From: Joe Russell-Wells
Sent: 12 April 2012 14:22
To: Cian Cronin
Subject: Country Fayre site planning application - FG/16/12 - Landscape comments
Follow Up Flag: Follow up
Flag Status: Red

LANDSCAPE PROPOSALS

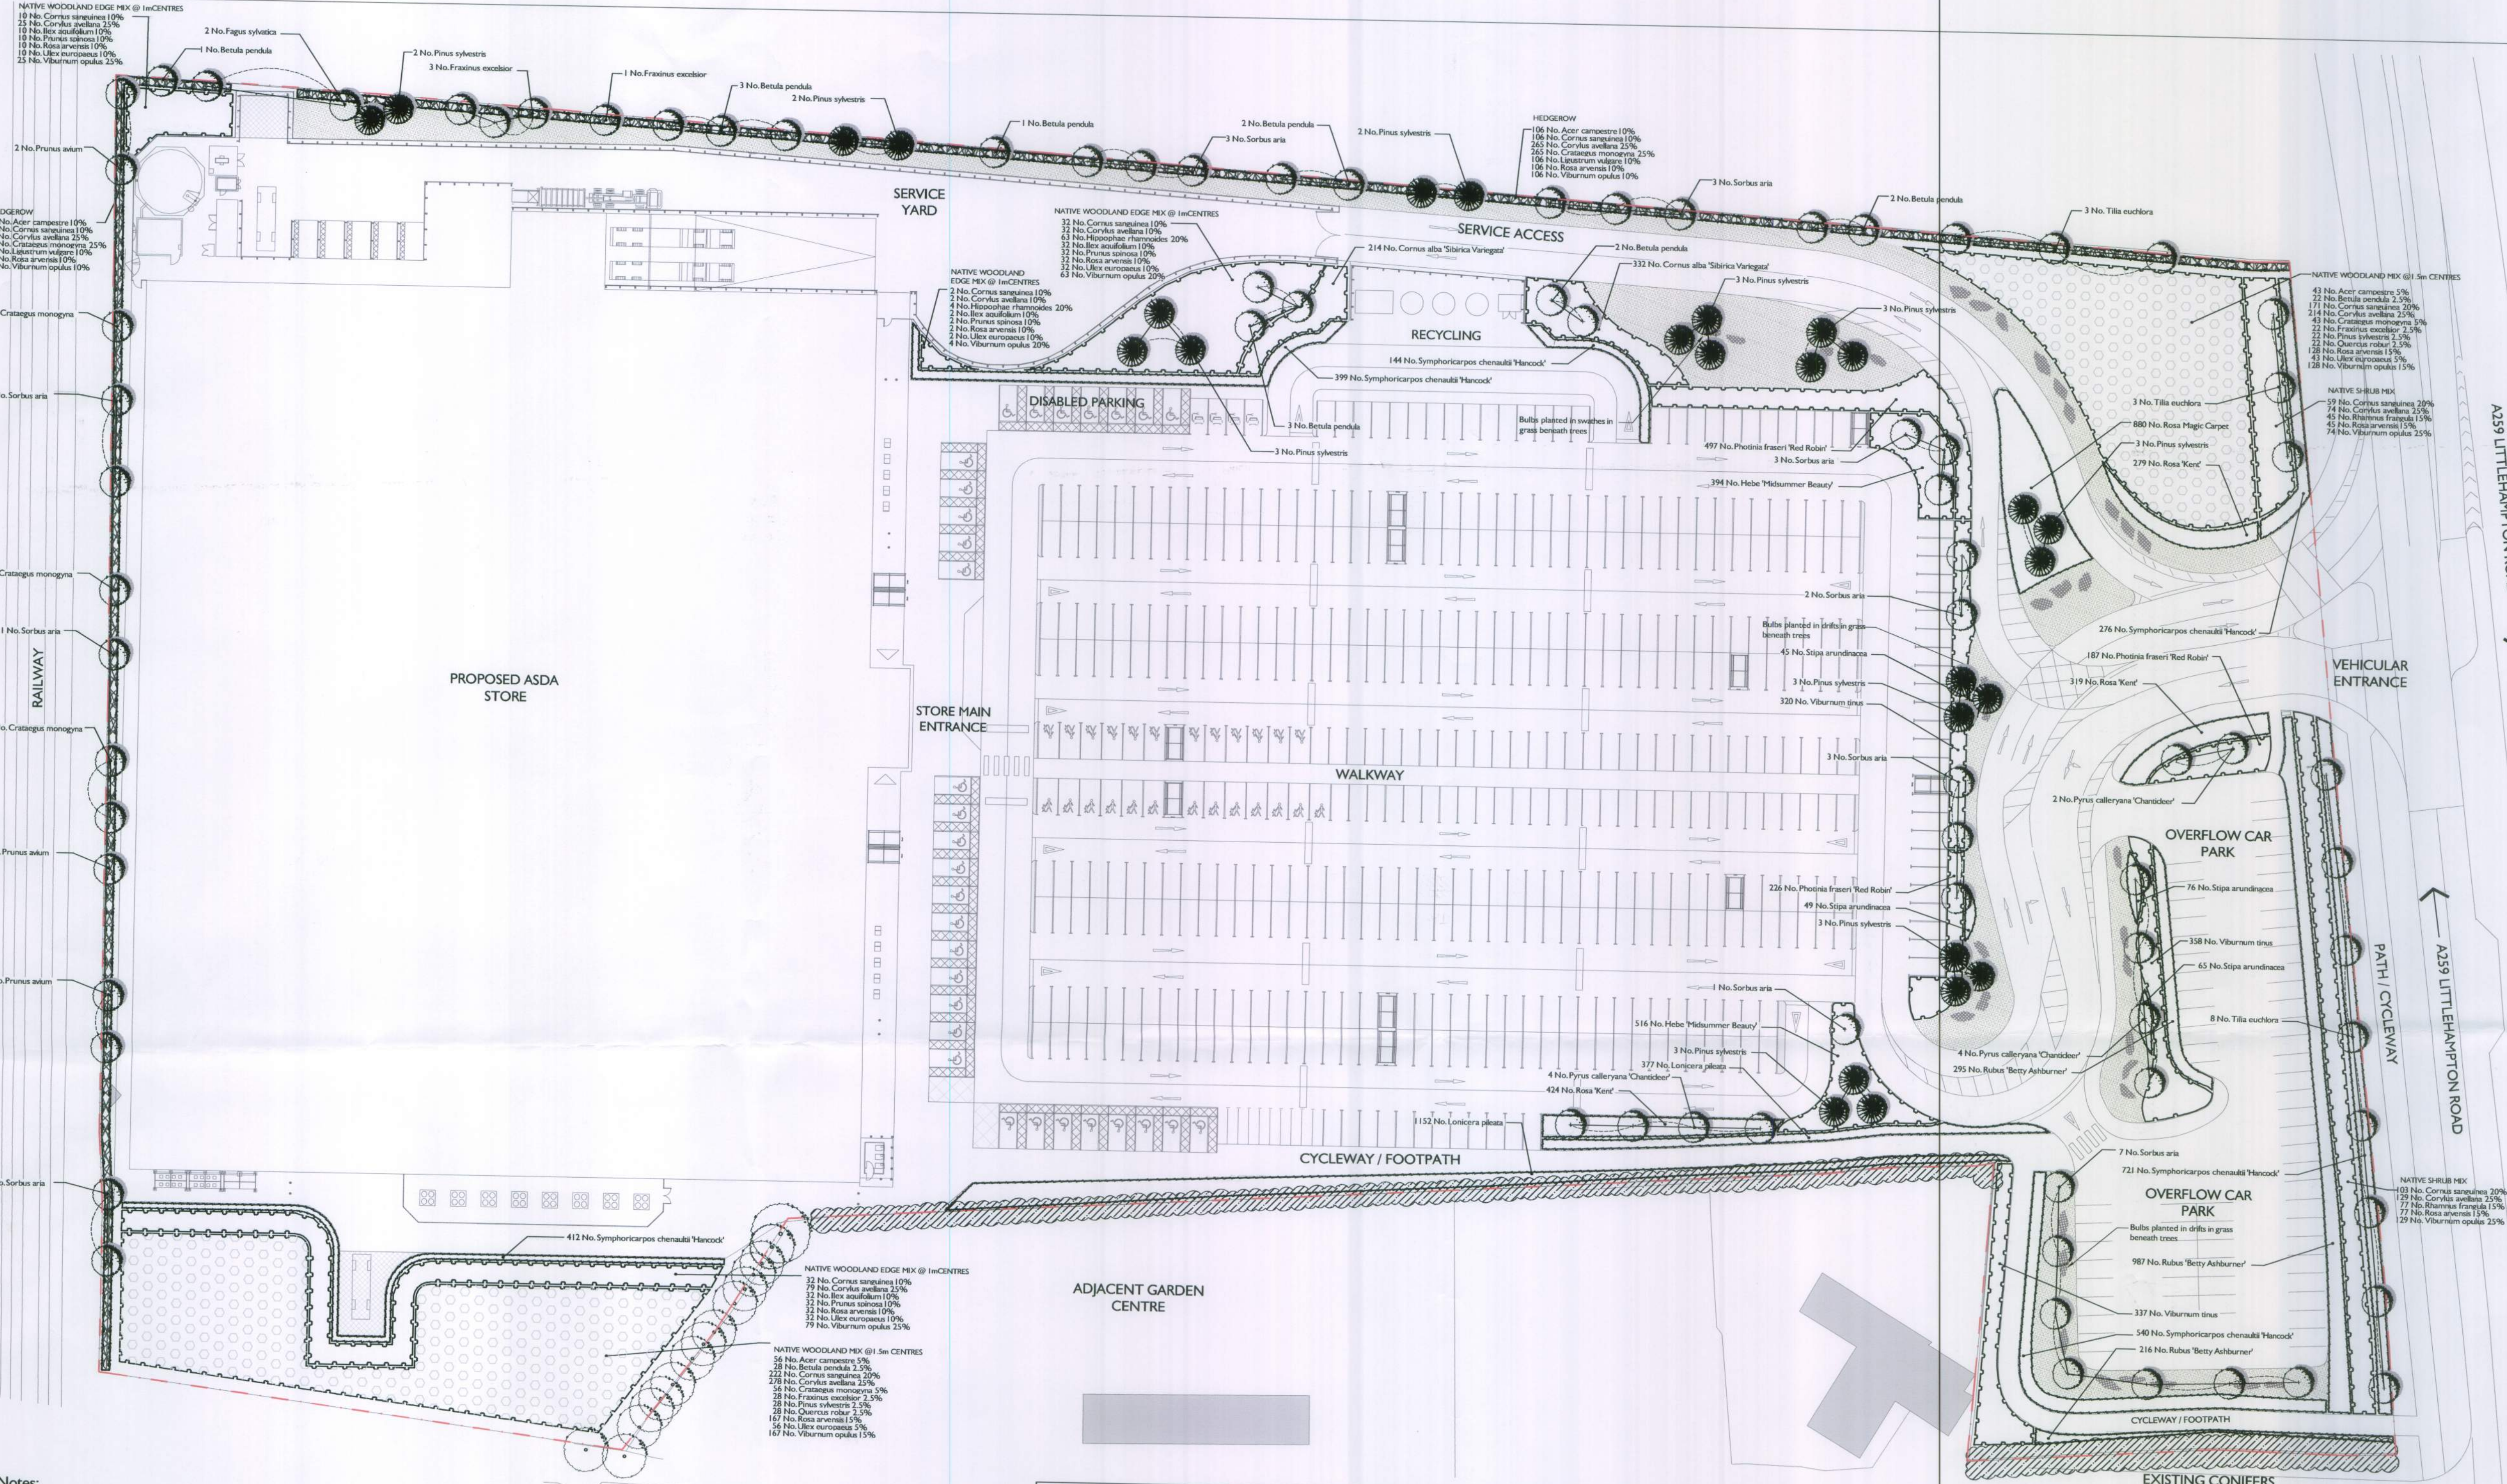
All previous comments on this site have focused on the boundary of the site with the undeveloped area to the west and the need to adequately screen this boundary from the development. As identified by Ian Brewster 22 Feb 2012 the boundary verge should be widened to allow for adequate tree growth which would allow for screening - this applies in particular to the area adjacent to the proposed building where the greatest need for screening is required. Ian Brewster commented on HGP Architects plan (dwg no 10.120.A(00)_02). The latest landscape plan (Indigo Landscape Architects Ltd dwg no 410-01 Rev B) appears to have addressed these comments by changing the species of tree to smaller varieties on the boundary which have a reduced screening capacity. The screening on the boundary is therefore unsatisfactory and needs to be further addressed.

The hedge proposed on the western boundary should be conditioned to grow and be maintained to a minimum of 2 m.

The sizes at the time of planting for all *Pinus sylvestris* must be specified and have an adequate impact at the time of planting.

The use of *Hippophae rhamnoides* (Sea buckthorn) must be excluded from the native (woodland and shrub) mix planting and hedgerow mix - it has a propensity to over dominate planting schemes once established.

The originally approved scheme included tree planting within the car park area. This greatly benefits the scheme; I would prefer to see this reintroduced.
